WILLOWTREE PLANNING

REF: WTJ20-395

Wentworthville Northside West Clinic Extension SSD-17899480

TABLE 1. DPE COMMENTS		
A. 10 October 2022 Comments		Applicant Response
1.	Provide a statement from the arborist clearly detailing the consideration of each individual matter listed in Clause 3.3.4 (b) to (h) of AS4970-2009 for trees 41, 48 and 49, to support the conclusion that each of the trees will remain viable for retention.	Please refer to the attached Arborist Statement from Birds Tree Consultancy dated the 14th October.

DA2001

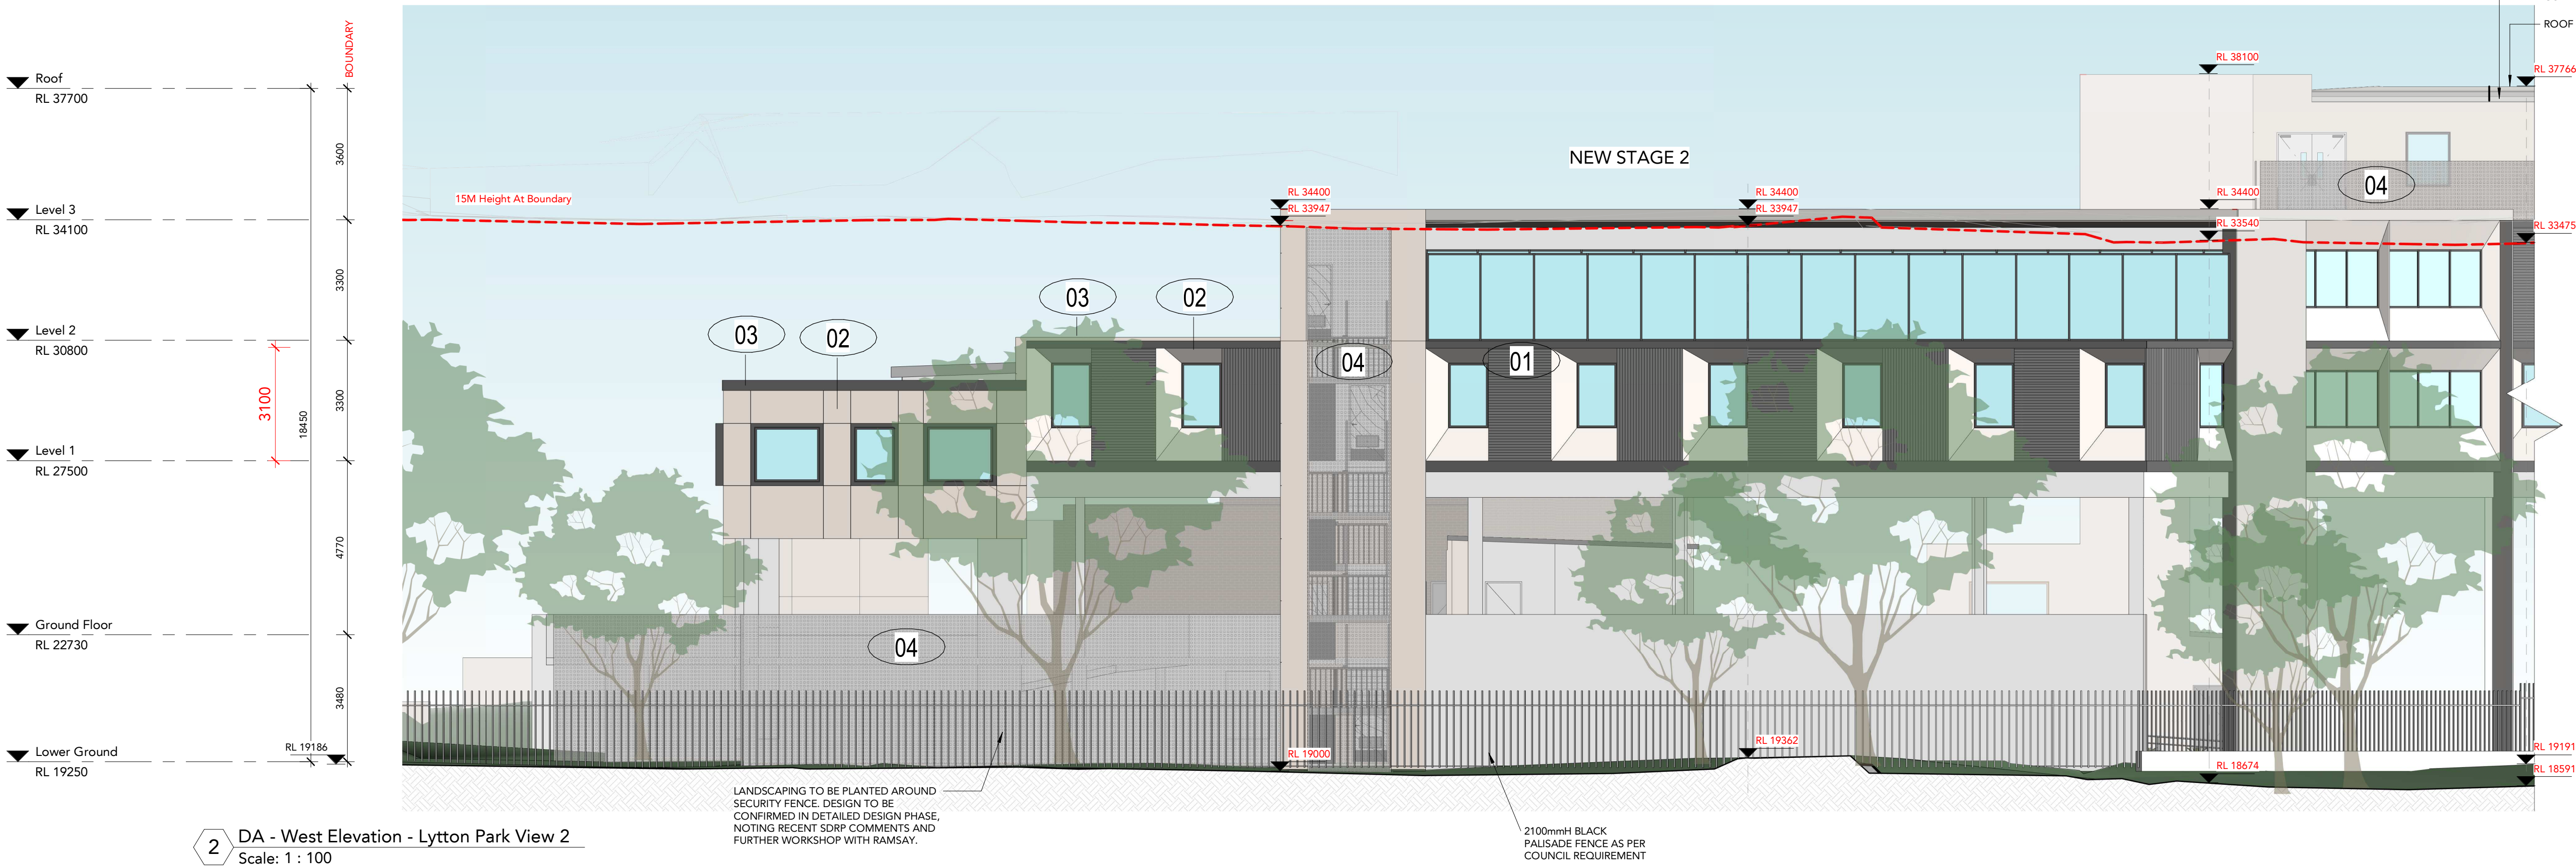
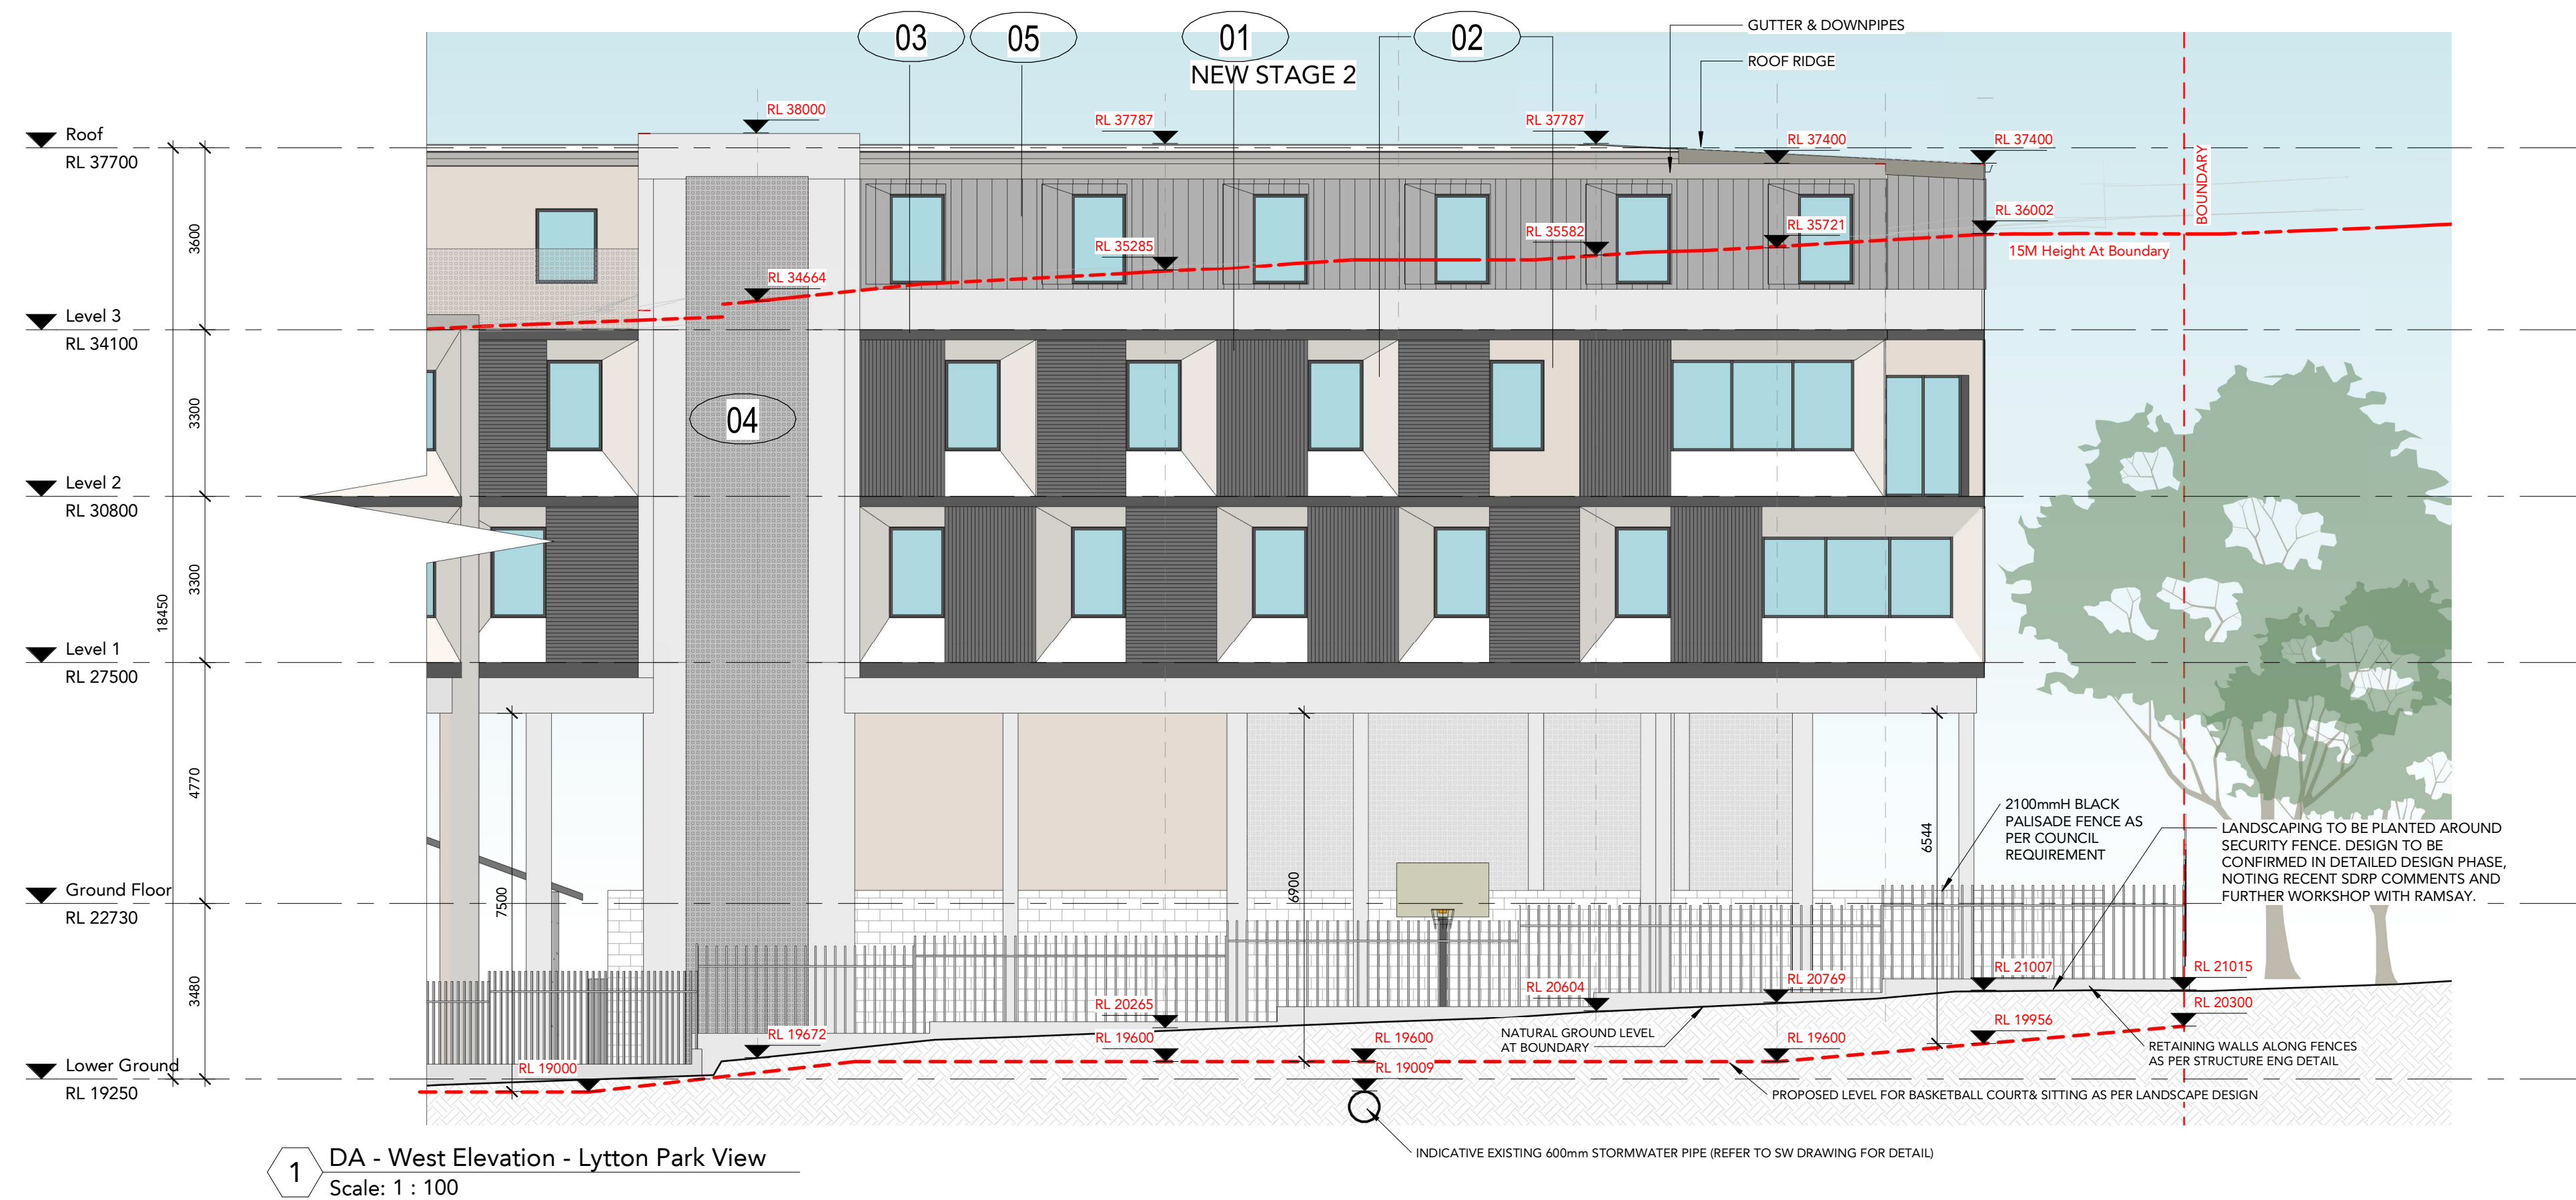
4.	Architectural plans must be updated to demonstrate a minimum 5.6 vertical clearance over the councils stormwater pipe and/or associated easements, as agreed by the Applicant in response to Council's submission to the RtS.	Please refer to attached Updated Architectural Plans drawings: 903-DA2001-ELEVATION-14, 903-DA3000-SECTIONS-15 & 903-DA8003-COURTYARD SHADOW DIAGRAM- WINTER SOLSTICE-5

CLIENT SIGN OFF		Wentworthville. NSW 2145	
Signature:		Title:	COURTYARD SHADOW DIAGRAM-
Name:		Name:	WINTER SOLSTICE
Date:		Date:	903
		Scale:	1 : 100
		Author:	DA8003
		Checker:	5

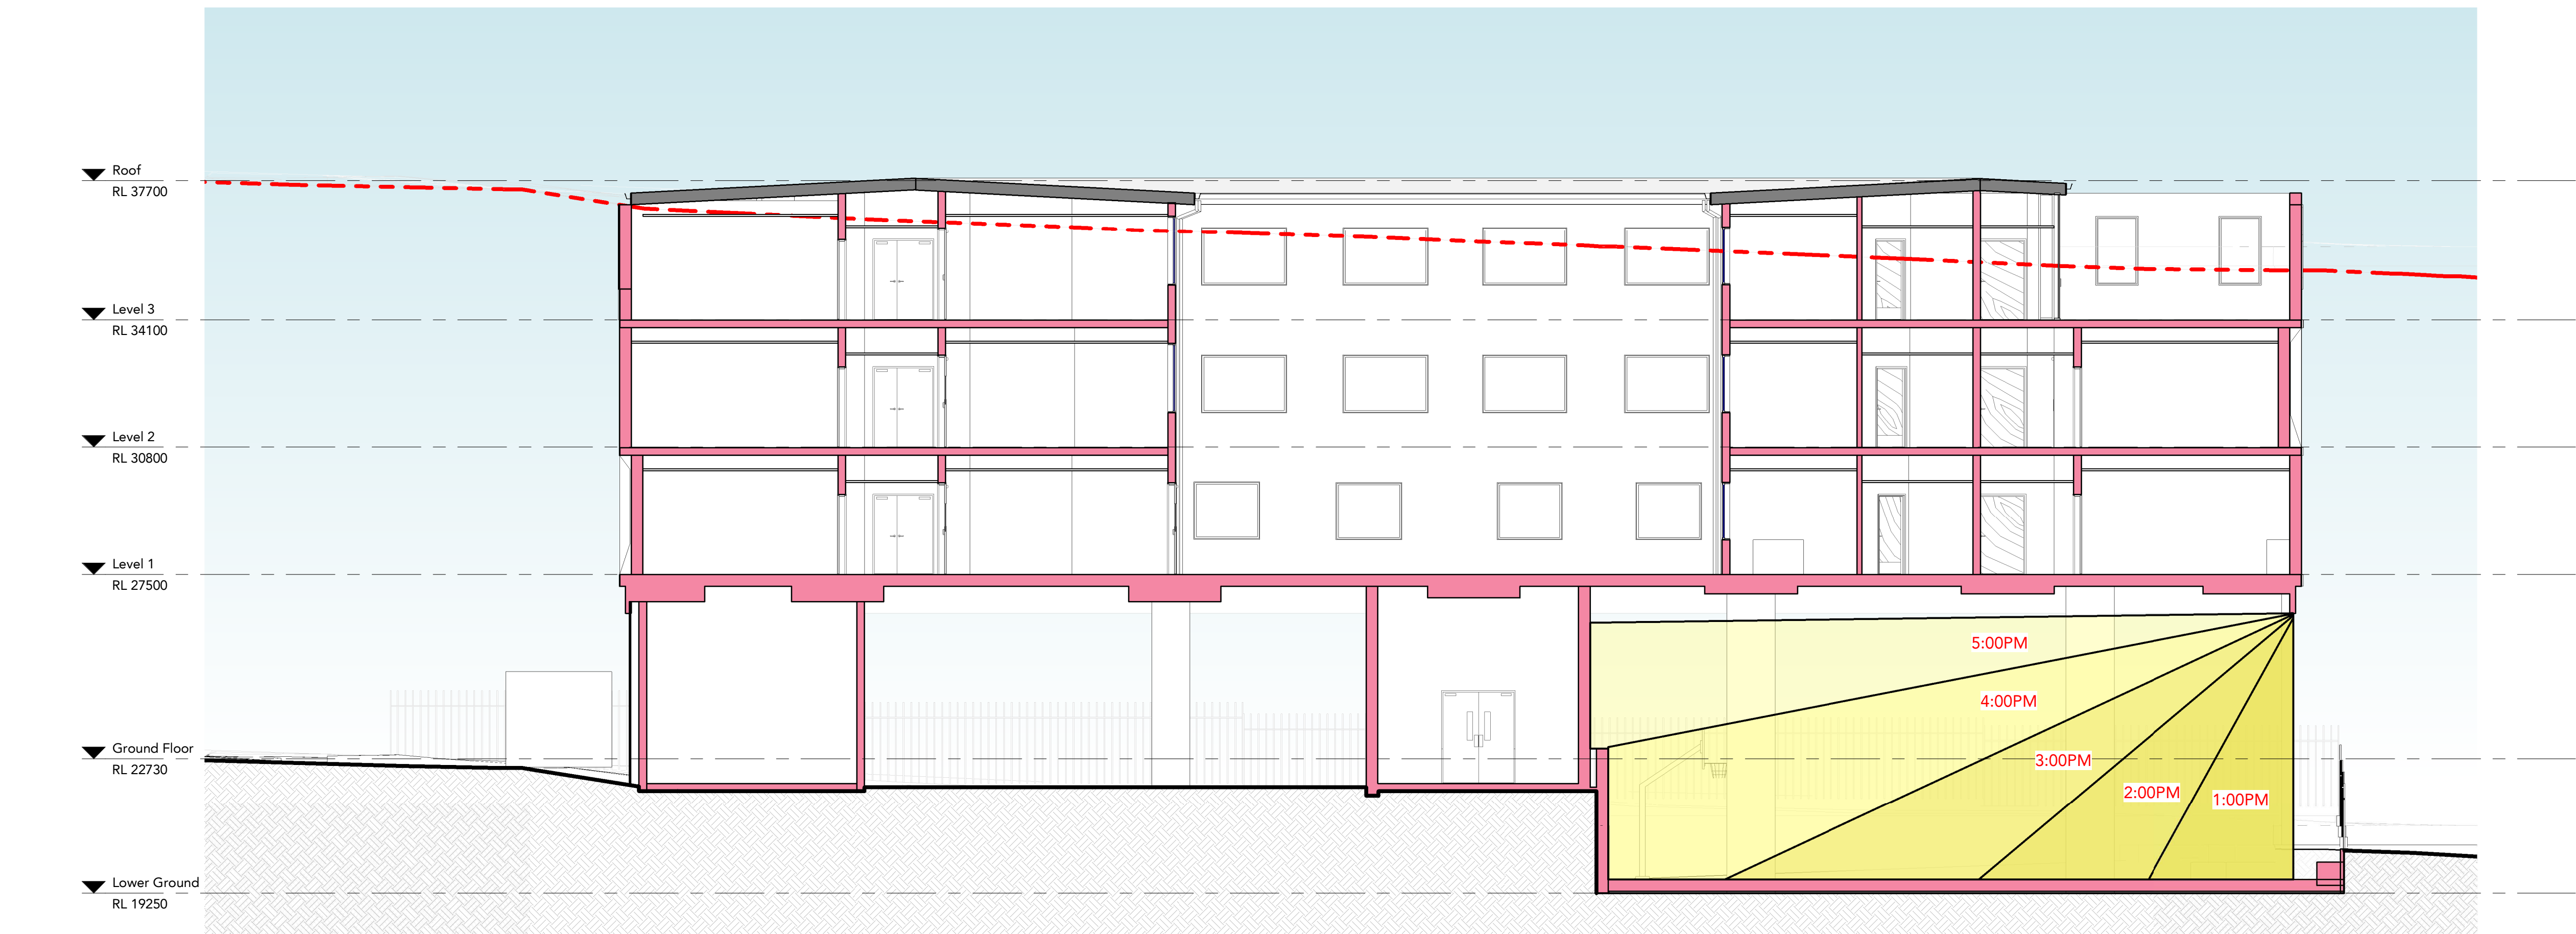
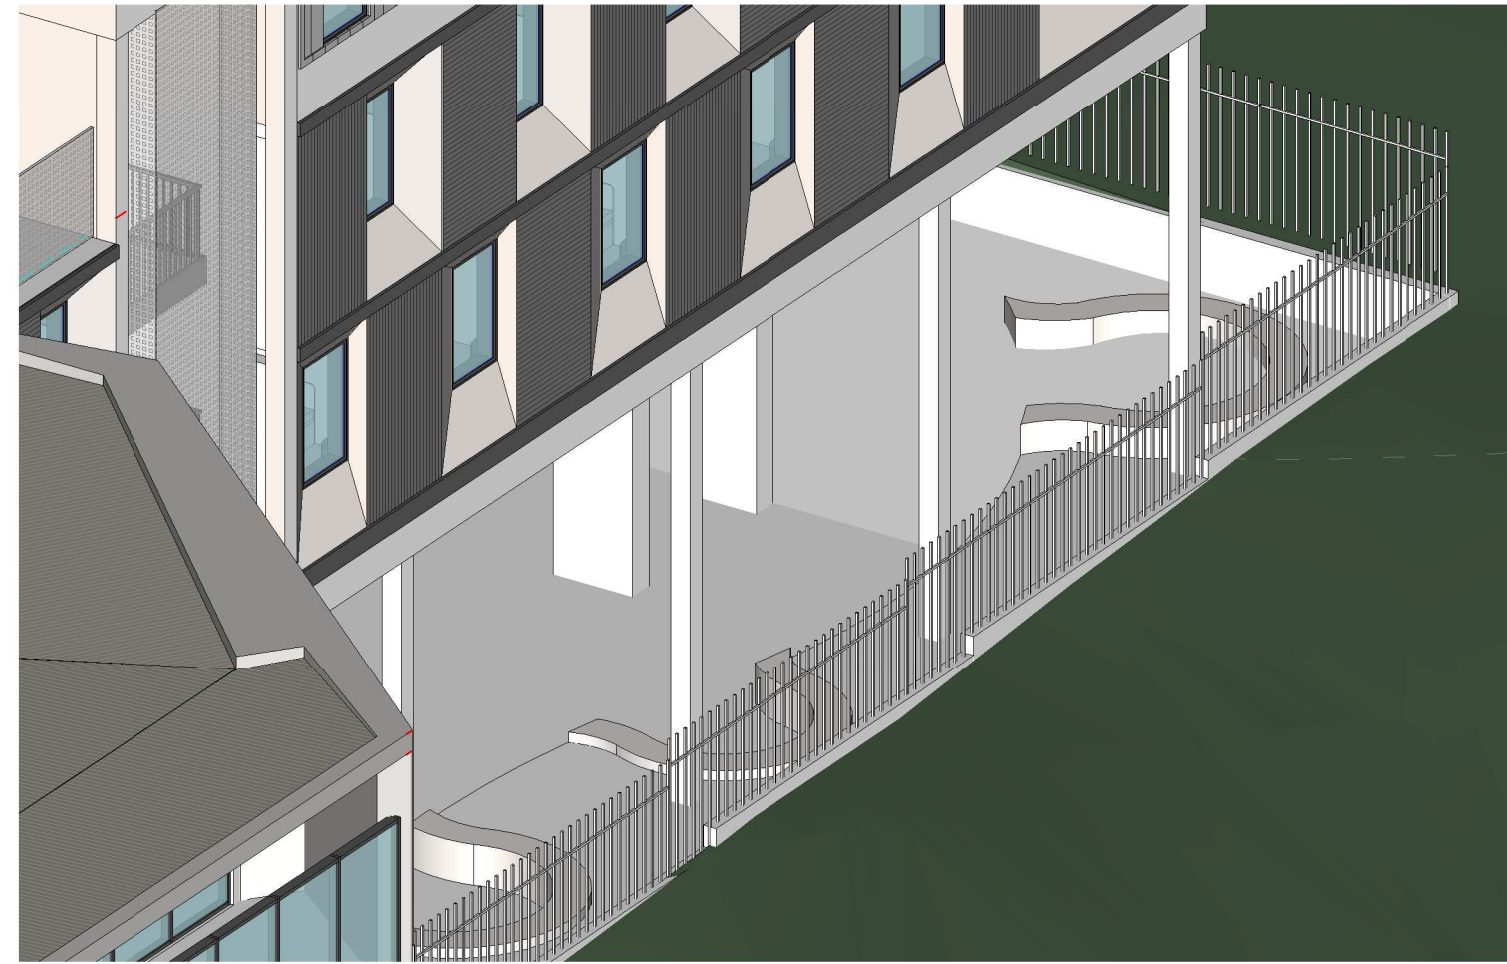
4.	Shadow diagrams in plan form should be re-submitted for the lower ground floor courtyard (basketball court), per previous drawing package.	Provided as per item 4 above.
